**Kemps Creek Estate Mod 3 (SSD-9522-Mod-3)
Request for additional information**

I refer to the Response to Submissions submitted to the Department of Planning and Environment (the Department) for the proposed modification to the Kemps Creek Estate (SSD-9522-MOD-3). The Department is requesting that you provide additional information.

Attachment 1

## APPENDIX 1 DEVELOPMENT LAYOUT PLANS

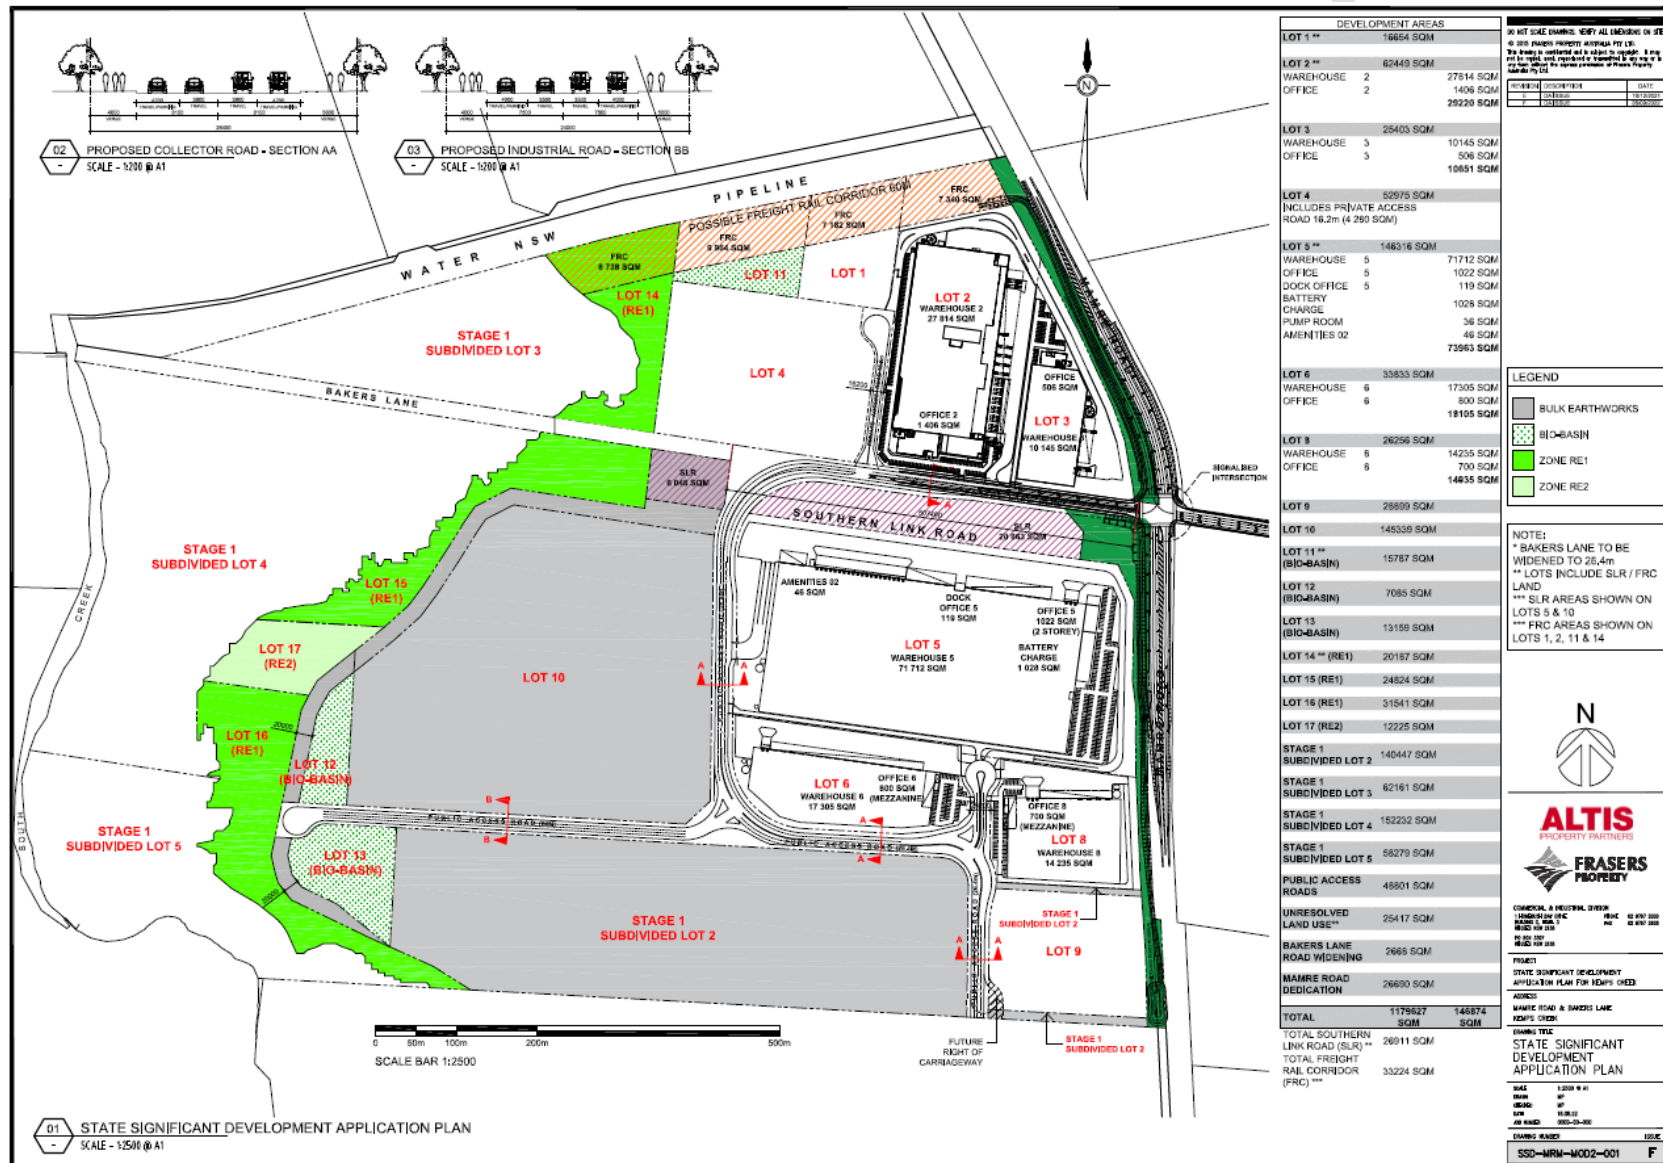
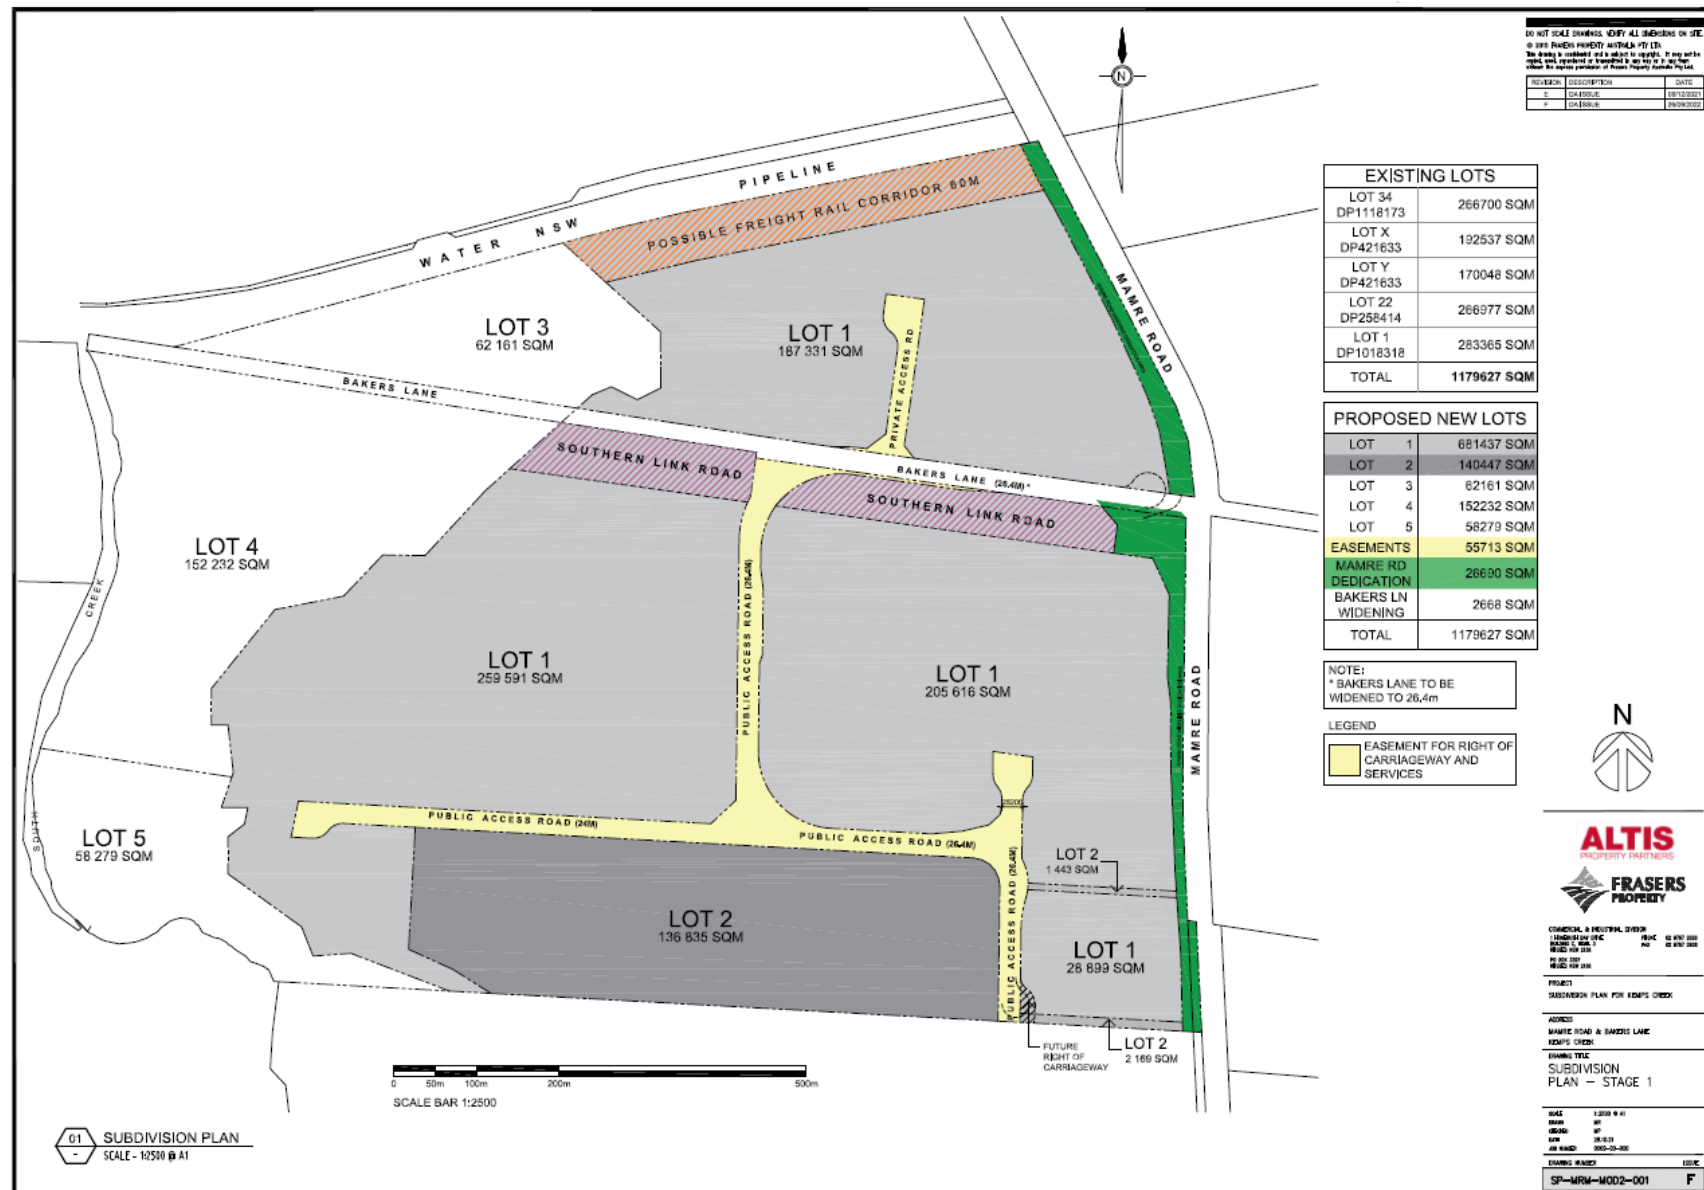
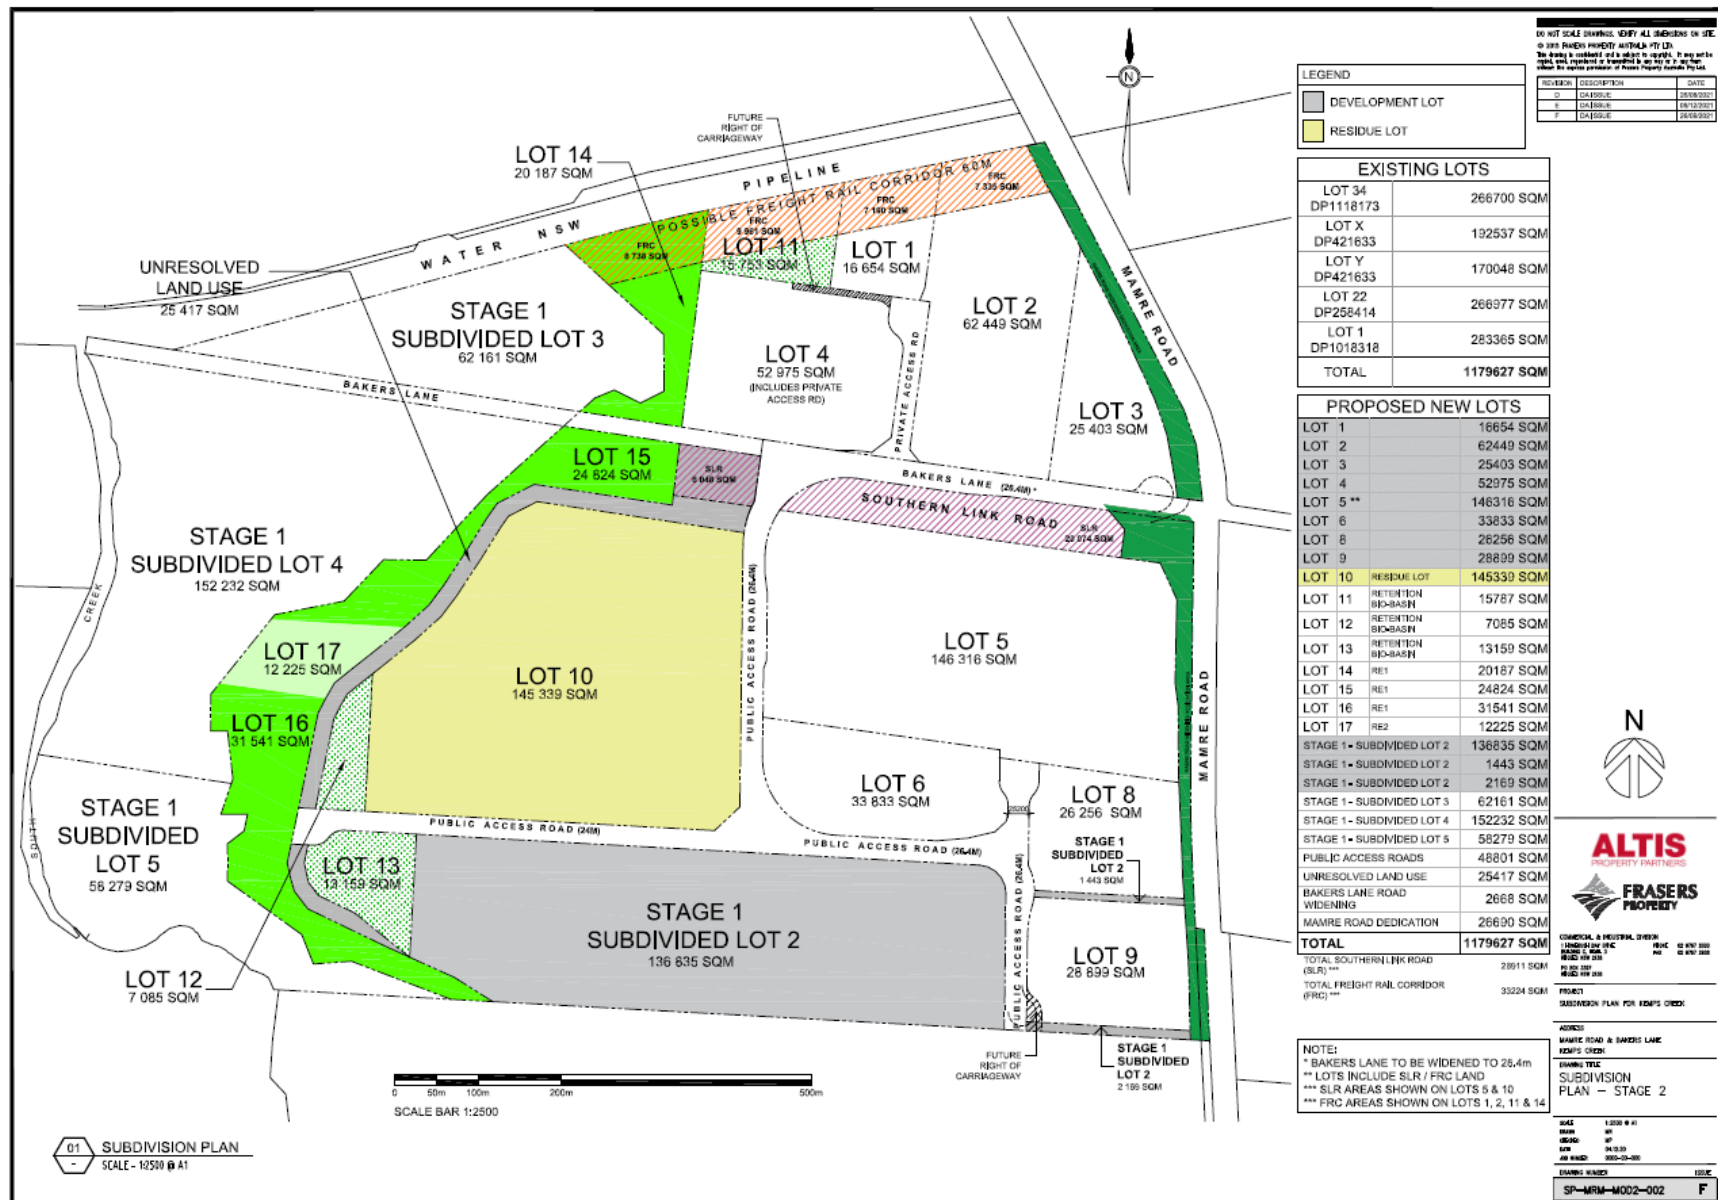
- As requested previously, please provide updated versions of the site and subdivision plans at Appendix 1 of the consent for SSD-9522 that reflect the modified site layout.

Figure 1: Noise Receptor Locations

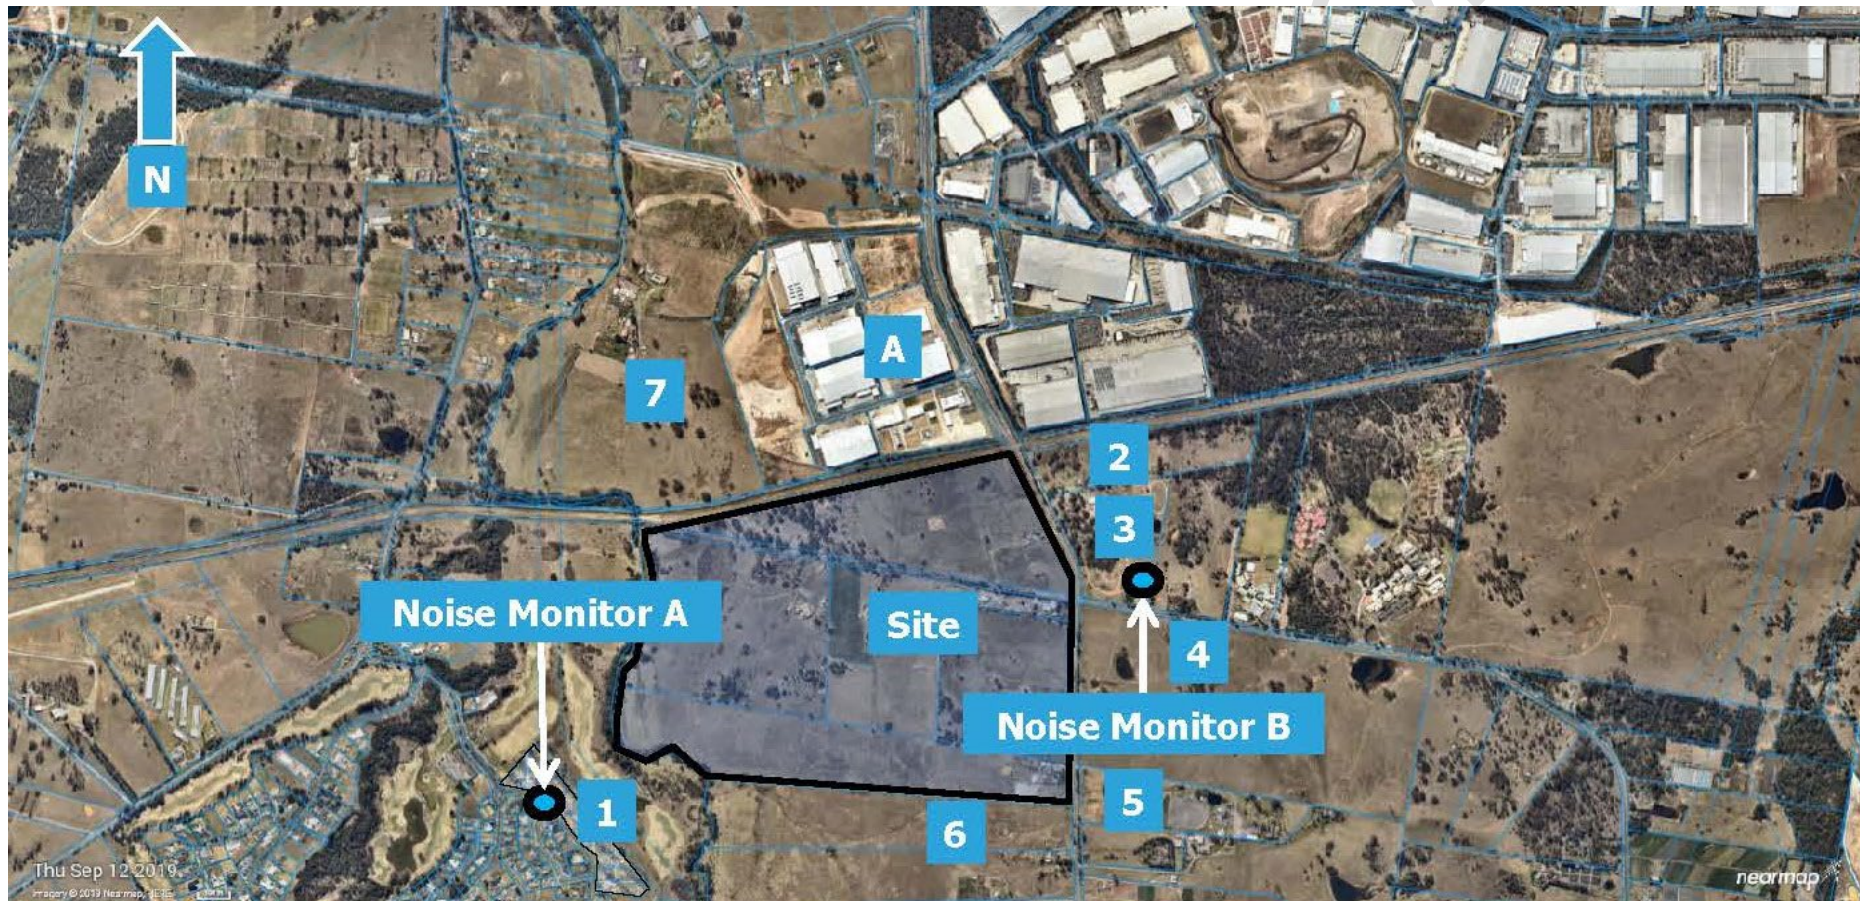
- The Department acknowledges that Receivers 4, 5 and 6 are subject to current development applications for industrial development and/or have been demolished. However, consideration of other existing residential receivers within the Precinct is still required, and you must demonstrate how the modified development can achieve compliance with the current noise limits under Condition B52 at receivers within the precinct that are not subject to current development applications for redevelopment.
